Byers Gill Solar EN010139

3.3 DCO Schedule of Changes

Change Application - October 2024

Revision 2

Drawing Title  
**Street Works, Public Rights of Way & Access Plans**  
Sheet 11 of 13  
**APFP Regulation 5(2)(k)**

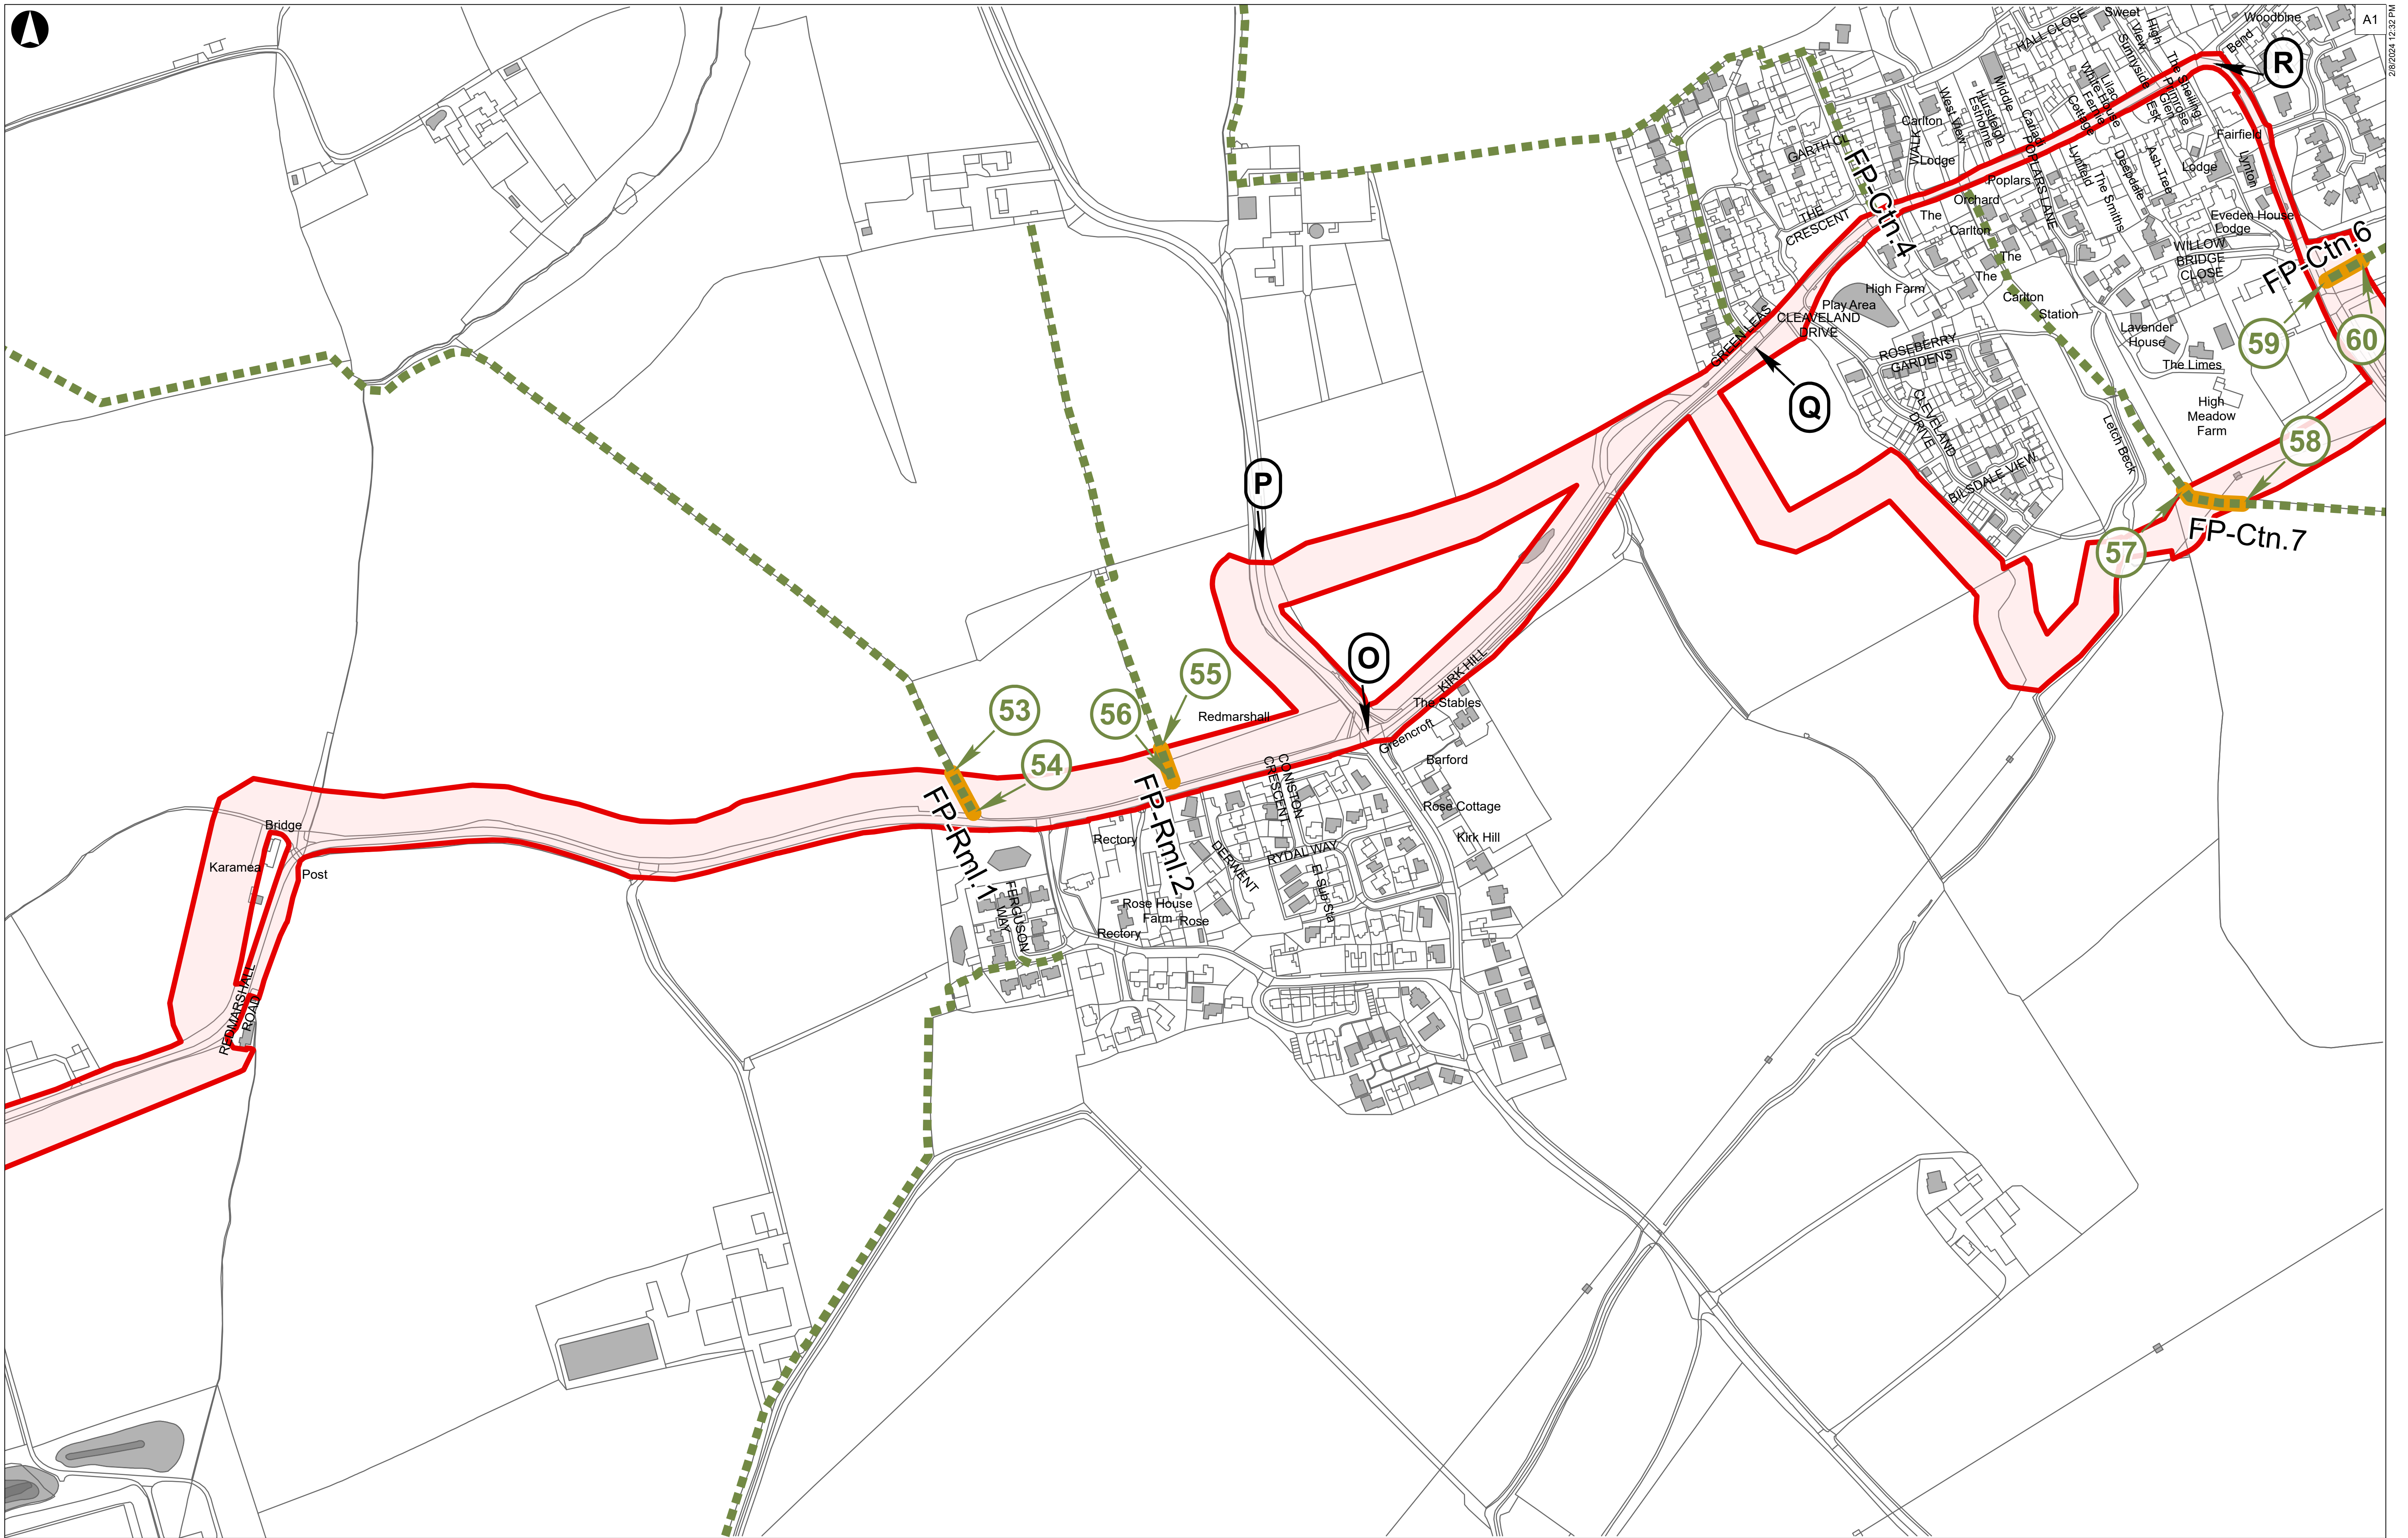
Within the table of street works in Schedule 3, two rows have been added as follows:

Parish of Bishopton	Folly Bank	Cable works beneath the width of street as shown with reference CC5 on sheet 9 of the street works, public rights of way and access plans.
Parish of Redmarshall	Redmarshall Road, in the vicinity of Morrington Bridge	Cable works beneath the width of street as shown with reference CC6 on sheet 11 of the street works, public rights of way and access plans.

These two rows have been added to provide street works descriptions for two locations where the Applicant proposes to carry out cabling works across the width of a street for the purpose of delivering the off-road cable route. These descriptions are included as a correction to Revision 1 of the dDCO.

Corresponding amendments have been made to the Street Works, Public Rights of Way and Access Plans to indicate these locations.
